Our ref: HA/2011/111266/01-L01
Your ref: BR/341/10/
Date: 17 February 2011

**OUTLINE APPLICATION WITH SOME MATTERS RESERVED FOR THE
DEMOLITION OF DERELICT 2 STOREY OFFICE BUILDING & ERECTION OF 8
NO. 2 BED FLATS & 6 NO. 1 BED FLATS WITH GROUND FLOOR PARKING,
BIN & CYCLE STORAGE & CHILDRENS PLAY AREA
FORMERLY WESTSIDE SUPPLIES 17/18 DURBAN ROAD BOGNOR REGIS**

Environment Agency position

BLOCK & SITE LAYOUT PLAN

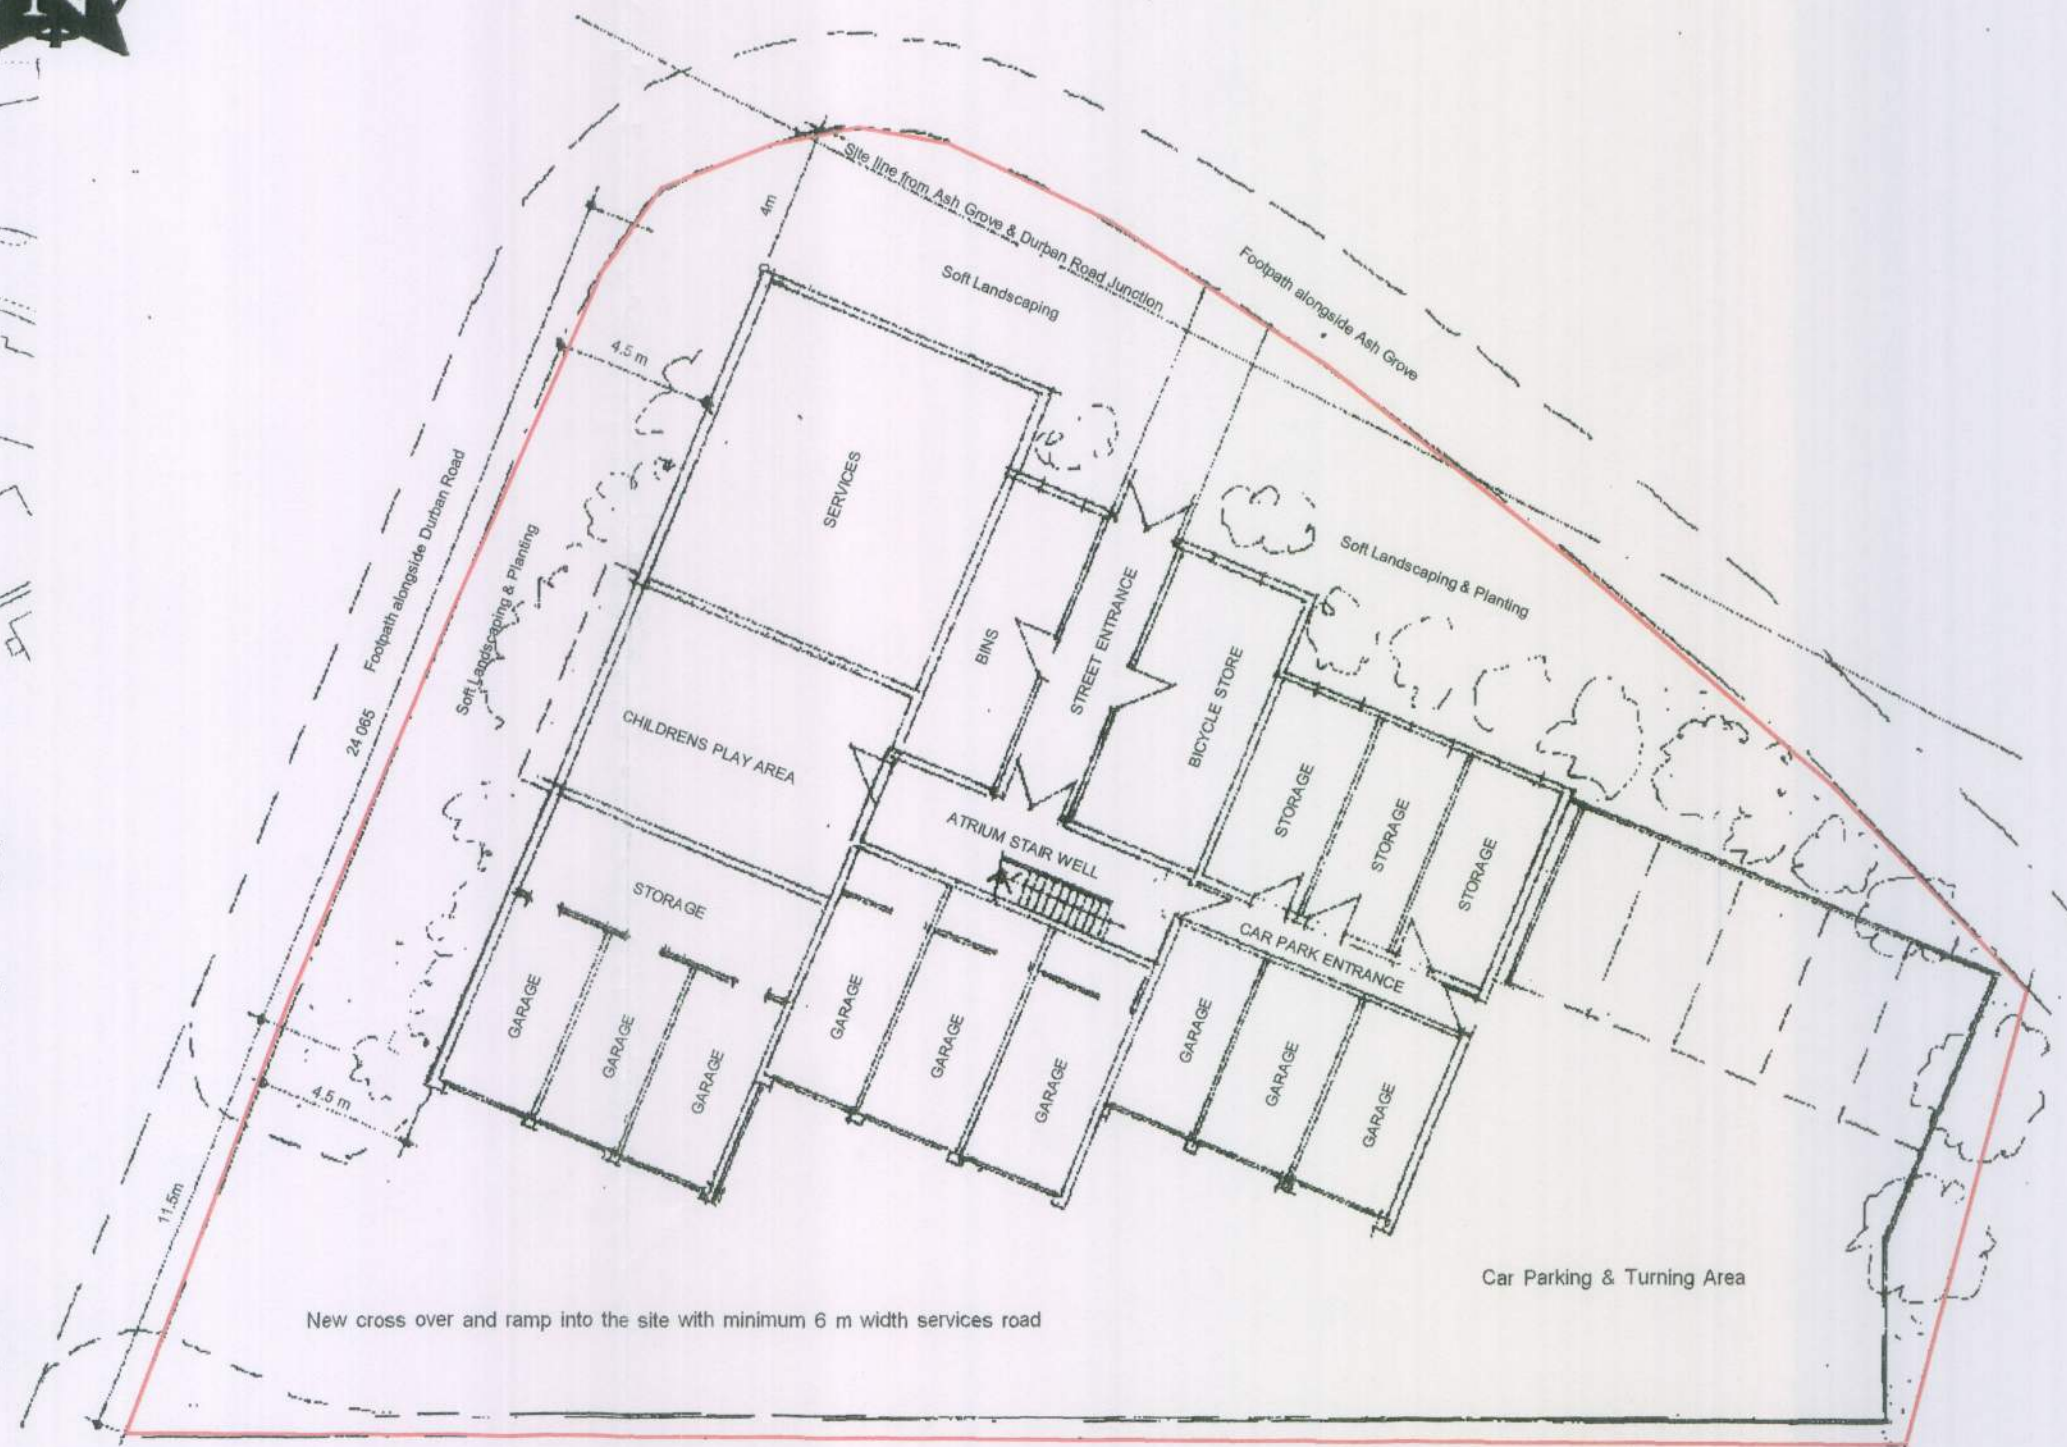
The development permitted by this planning permission shall only be carried out in accordance with the approved Flood Risk Assessment (FRA) and the following mitigation measures detailed within the FRA:

1. Finished floor levels are set no lower than 2.2 m above Ordnance Datum (AOD).
